Permit No: **980285**

**Proposed Project Description:**  
 Construct Garage (12 x 24)  
*Left off street S*

# BUILDING PERMIT REPORT

DATE: 27/MARCH/98 ADDRESS: 122 Lynn St. (337C-083)  
REASON FOR PERMIT: To Construct Private garage (u) 12x24  
BUILDING OWNER: Mary E. Wilcox  
CONTRACTOR: Everett W. Dobson & Sons  
PERMIT APPLICANT: Jeff Dobson  
USE GROUP U BOCA 1996 CONSTRUCTION TYPE 5B

Setbacks

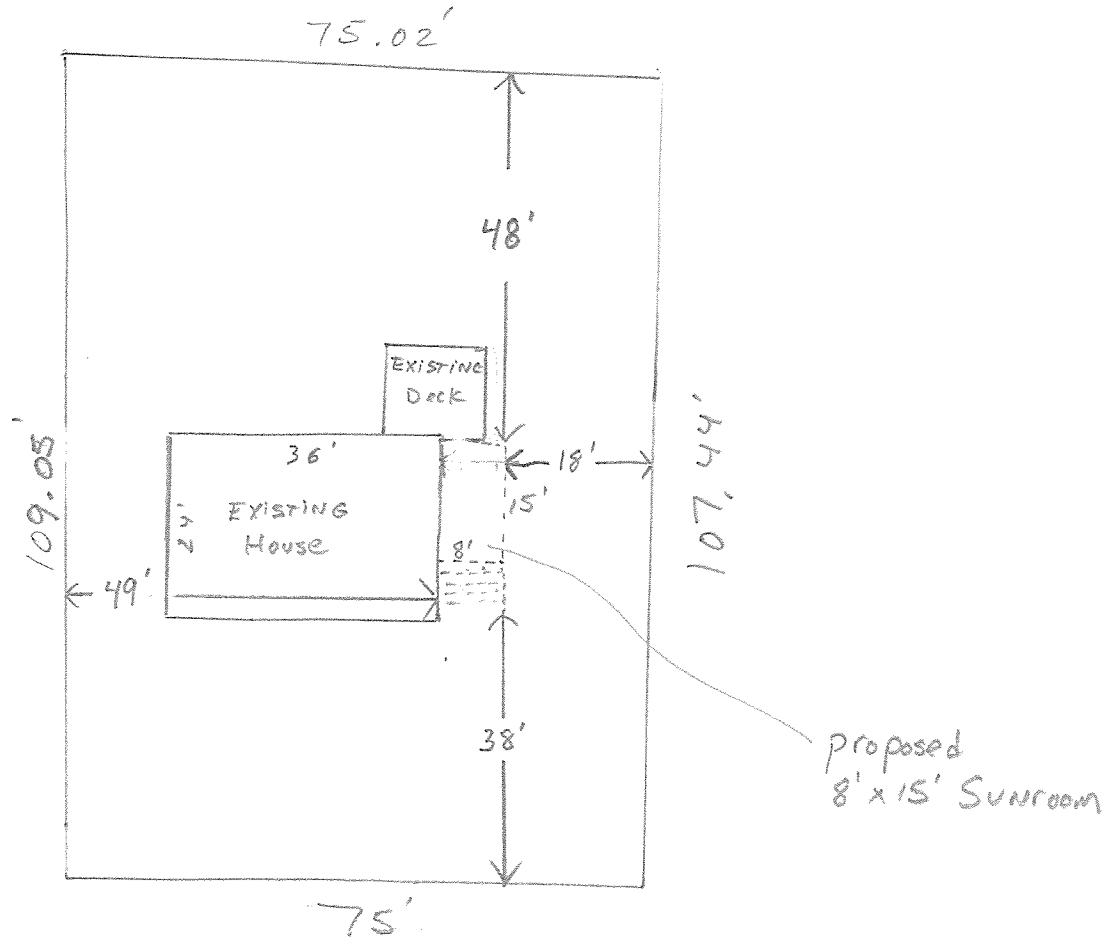
ok Side Yard - 12' req - 8' shown - ok per 14-433 which allows  
A 5' reduction on side provided Reg. setback could NOT be met. This is the narrowest a garage can be, plus it needs to line up with the existing driveway & still leave some space between the deck & the garage.
